RESPONSE TO SUBMISSIONS REPORT

BLACKTOWN MT DRUITT HOSPITAL BLACKTOWN CAMPUS STAGE 1 EXPANSION

**Job No. 11013
November 2012**

## Campus Entry Statement

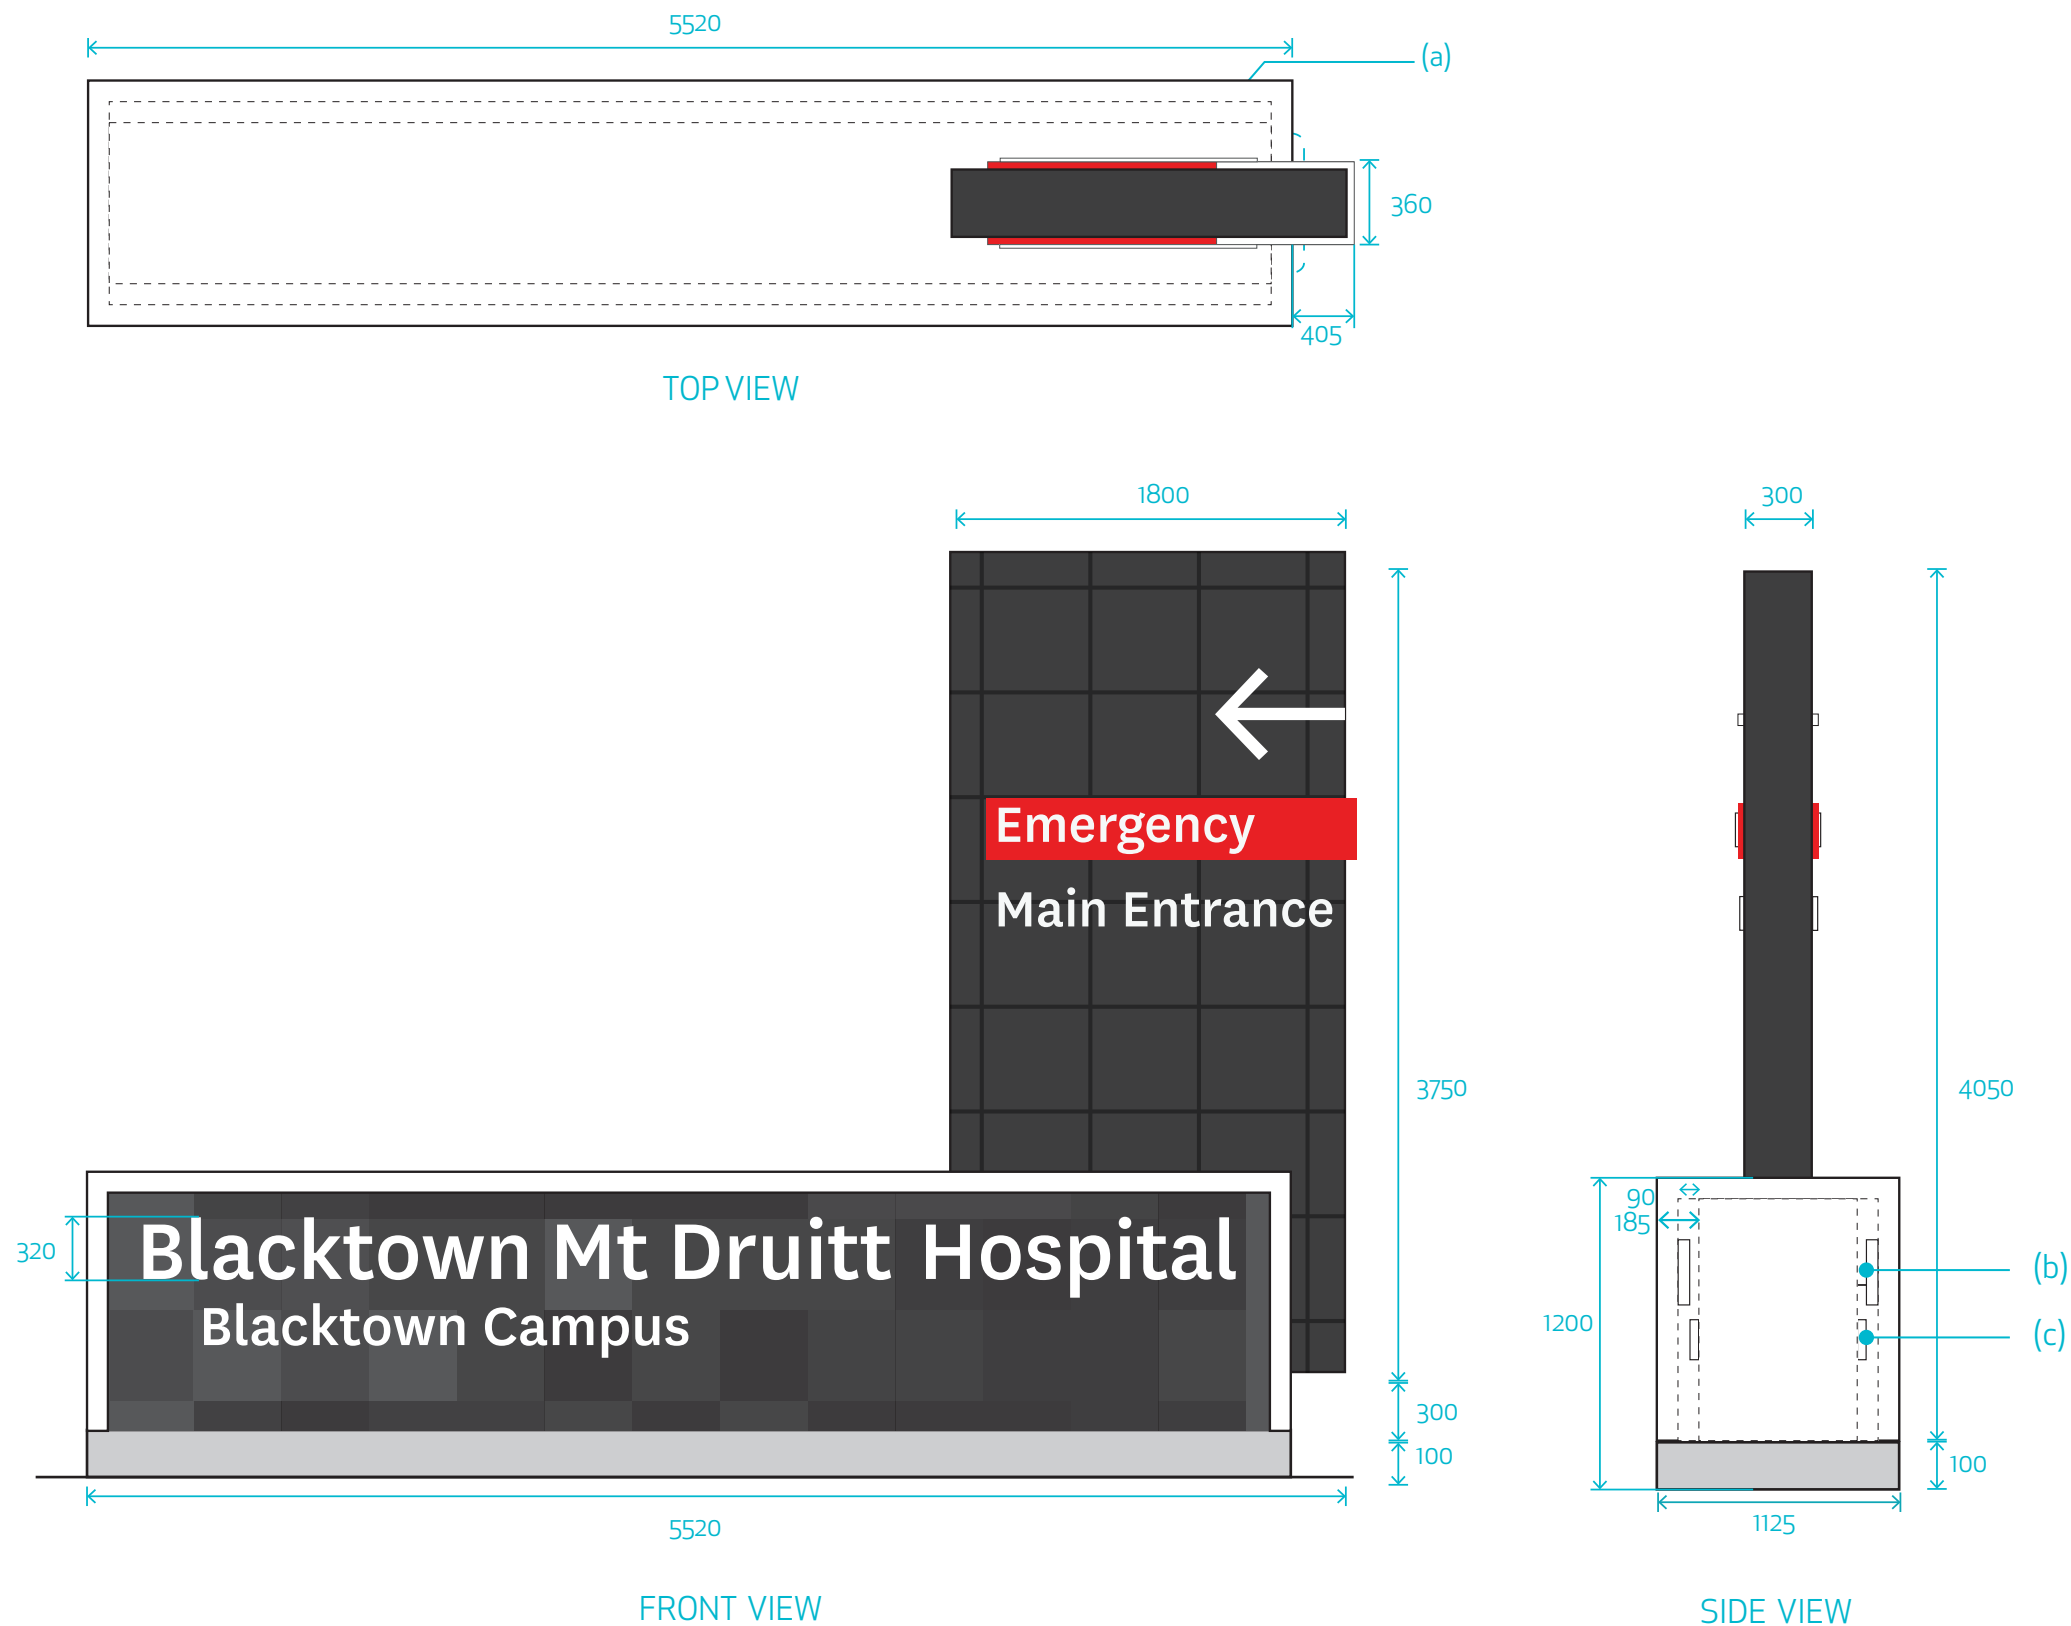
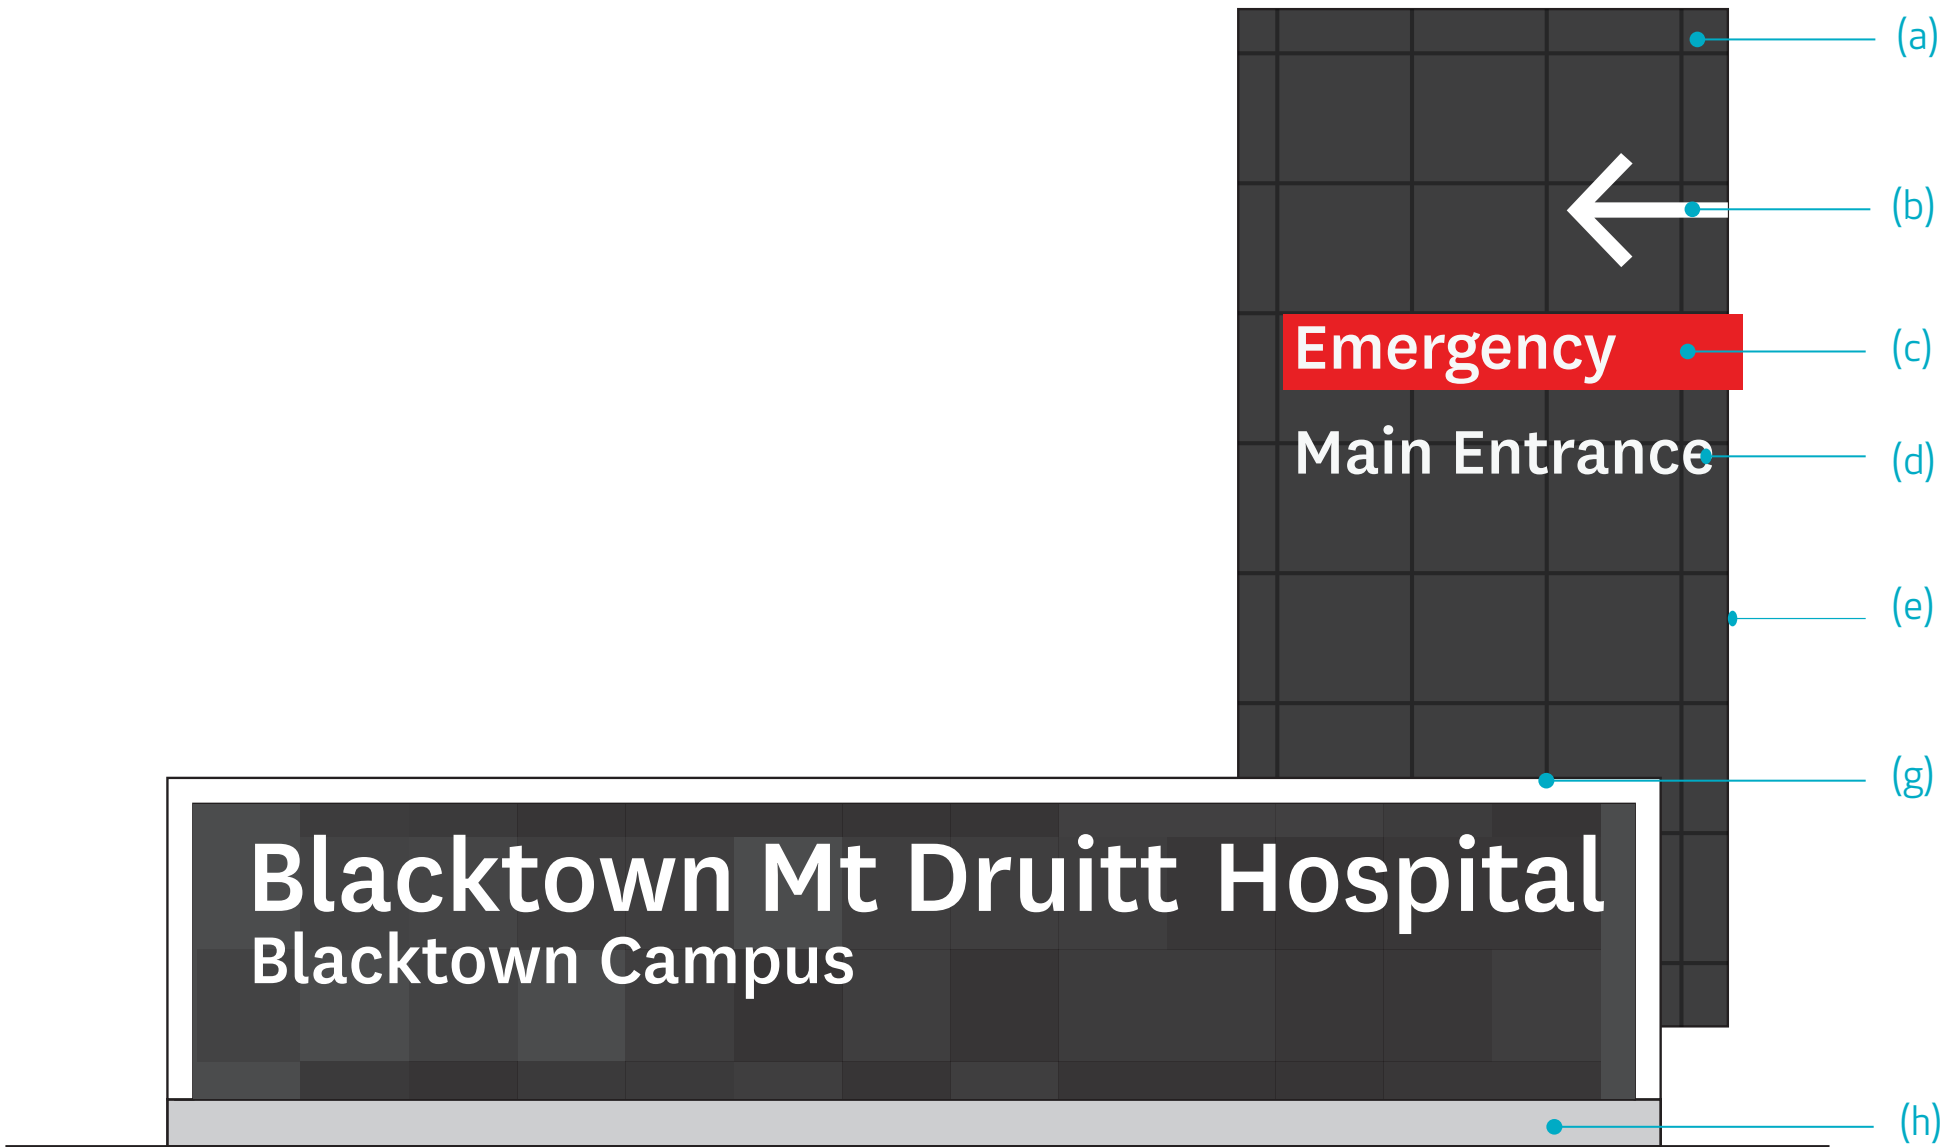
DoP&I have requested details of the proposed sign at the new entrance to the hospital. These details are provided in Appendix 3. The sign will be a business identification sign as defined under SEPP No 64 Advertising and signage. It is noted that the RMS has proposed a condition to the grant of its concurrence to an application for approval under S138 of the Roads Act, 1993 requiring signs to be constructed entirely within the property and to not have:

- flashing lights;
- electronically changeable messages;
- animated display;
- complex displays that hold a drivers attention;
- displays resembling traffic signs; or
- a method of illumination that distracts or dazzles.

The proposed signs do not have these characteristics.

The signs are proposed to be illuminated by internal lighting devices. This illumination would not result in unacceptable glare, would not compromise safety for pedestrians, vehicles or aircraft and would not detract from the amenity of any residence. The signage is not proposed to be subject to a curfew and the brightness of the lighting would not need to be adjustable.
